Mr. Evan Maxim  
Planning Manager  
City of Mercer Island, Development Services  
9611 SE 36<sup>th</sup> St.  
Mercer Island, WA 98040-3732

July 11, 2017

Re: **SEPA Comment:** CA-15-001 and SEP15-001 - MI Treehouse RUE and SEPA  
Determination

SOUTH ELEVATION

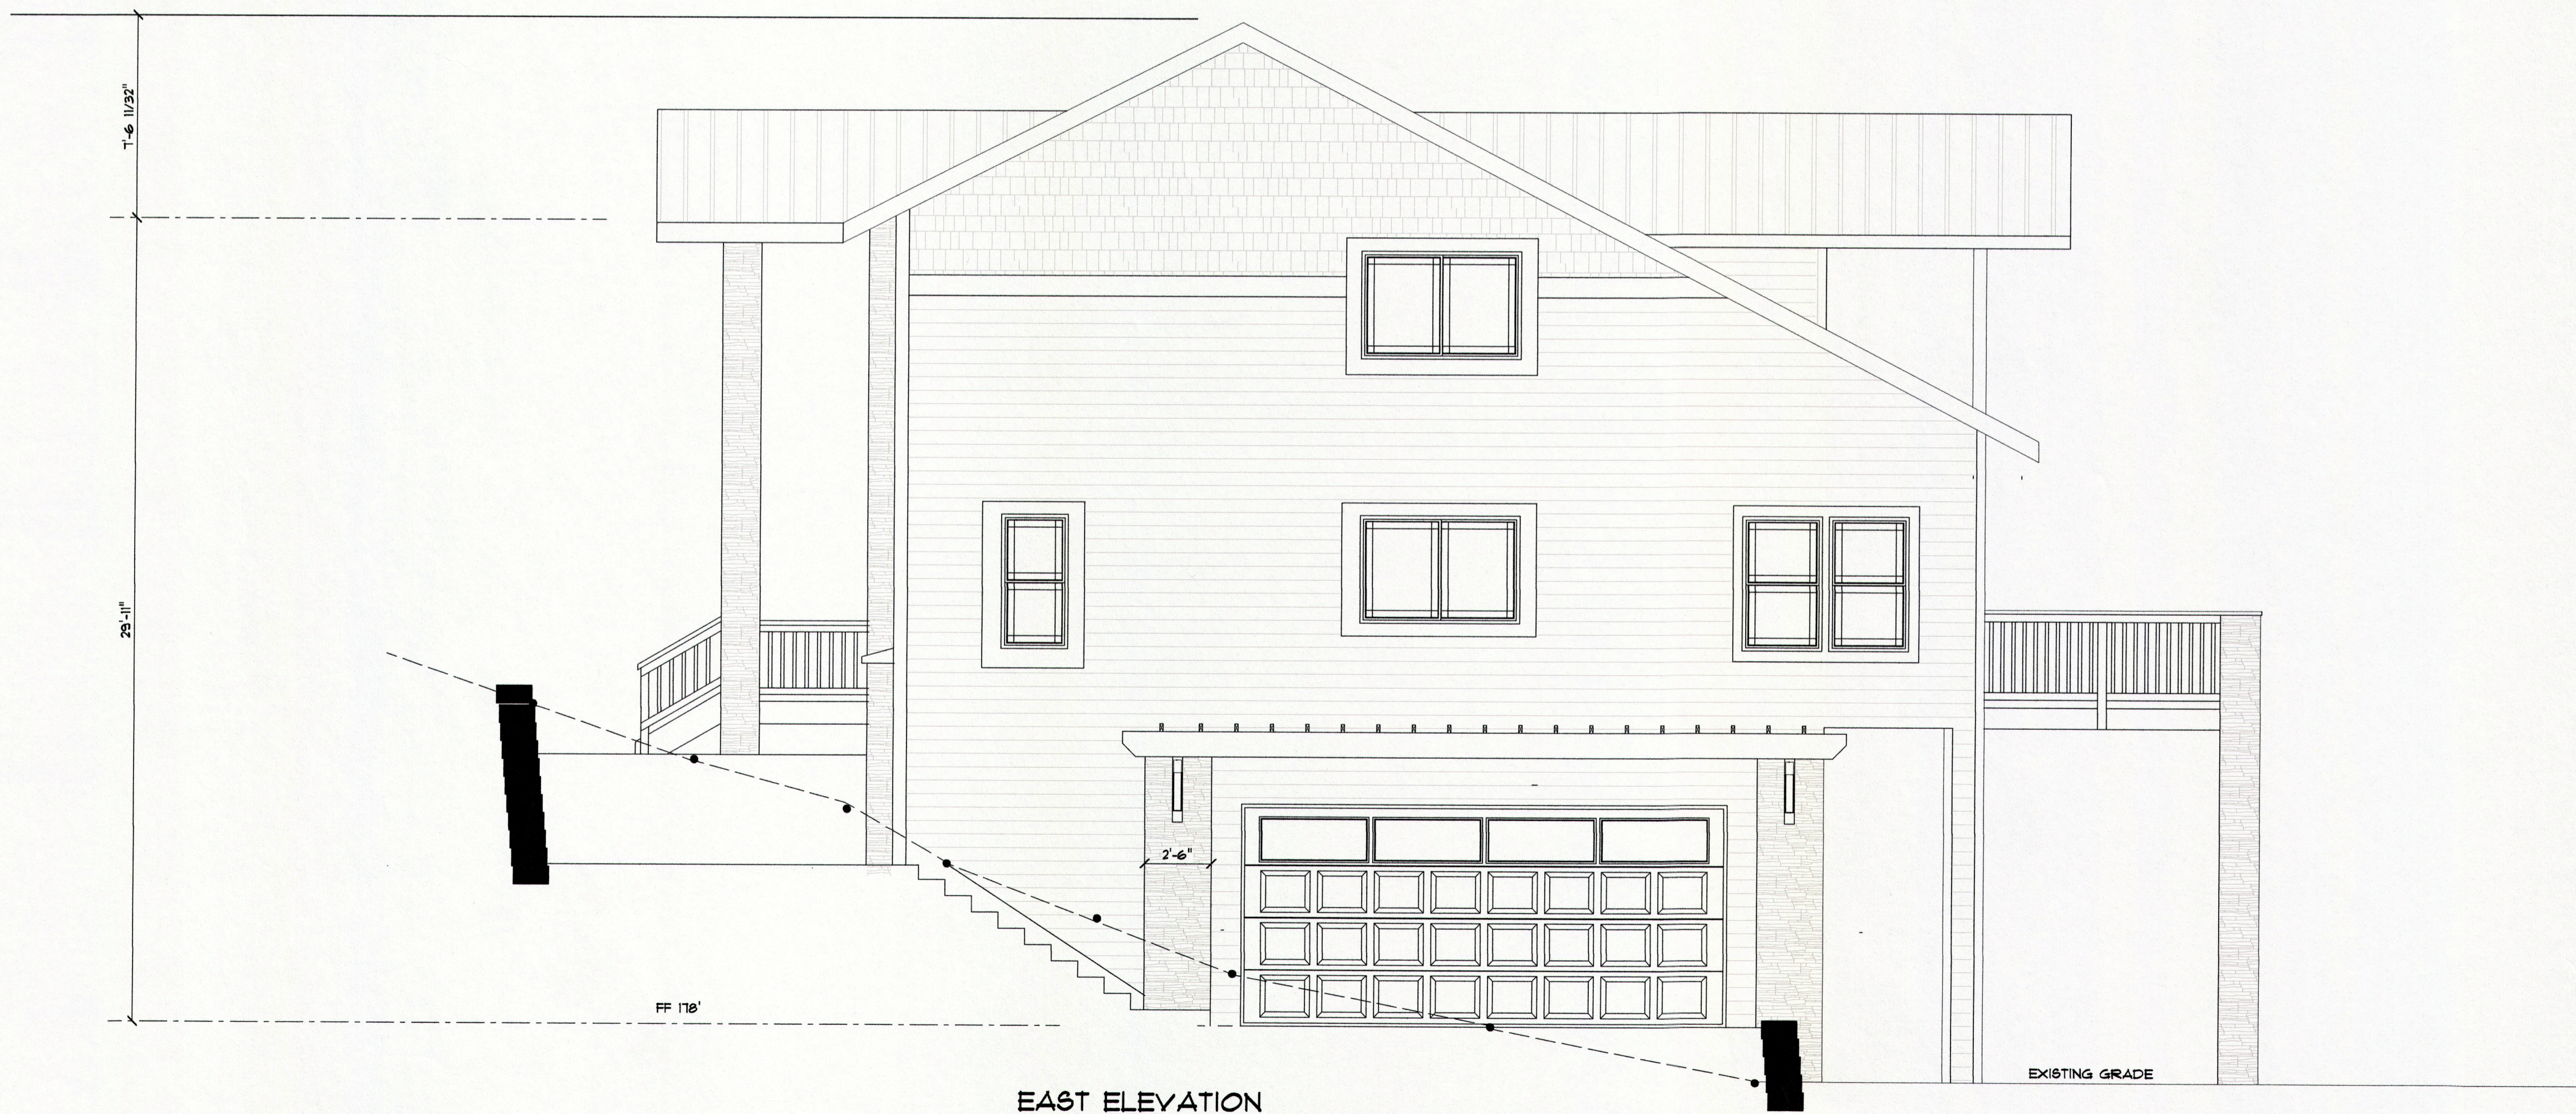
In response to the query relating to what views in the immediate vicinity would be altered or obstructed, the applicant's SEPA checklist states: "None." However, the impact of a two story residence supported by structural piles on the view and privacy of Dr. Stivelman's property directly to its south has not been addressed. This should be adequately addressed by the applicant, including a condition regarding height limitations, with additional appropriate mitigating conditions imposed.

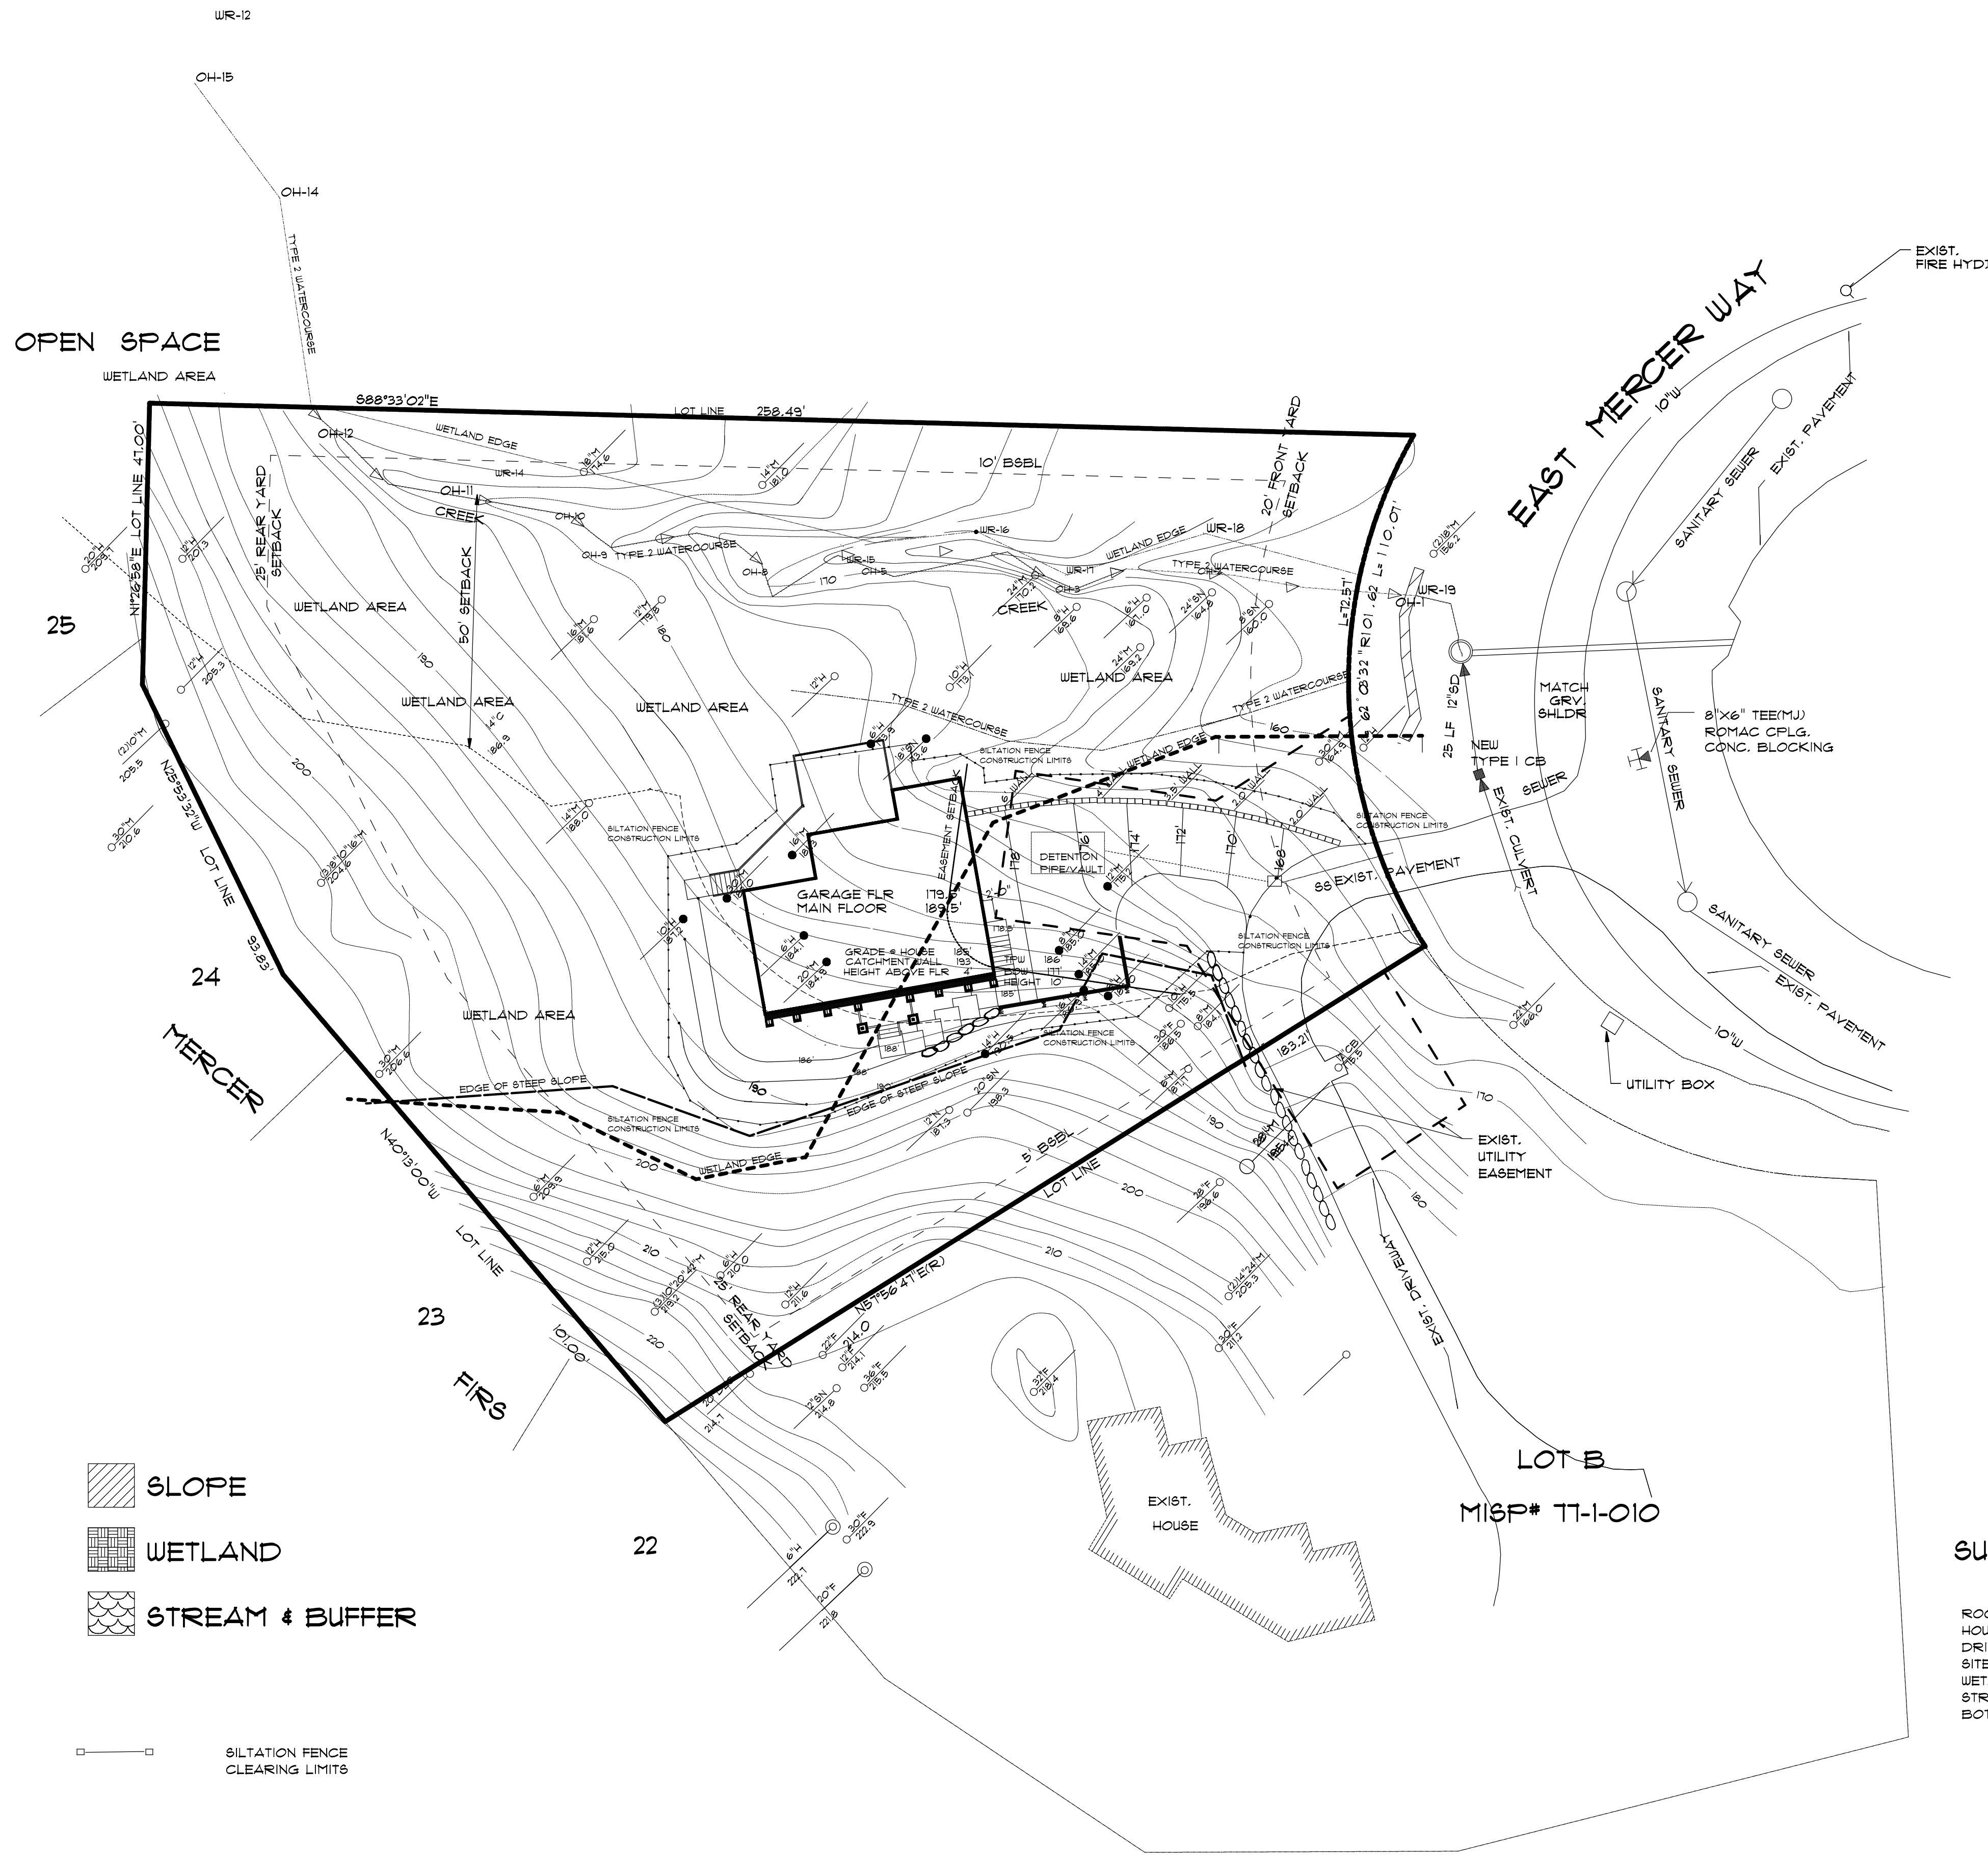
The applicant’s SEPA checklist states that a “small amount” of “insignificant native vegetation” will be cleared. This is inaccurate. The applicant’s site plan reflects 13 significant trees will be removed and only shows 11 of the 13 that will be removed. The applicant should identify the other 2 trees (identifying the height and diameter) sought to be removed and what measure will be taken to avoid erosion and protect the stability of the area of removal for all 13 trees.
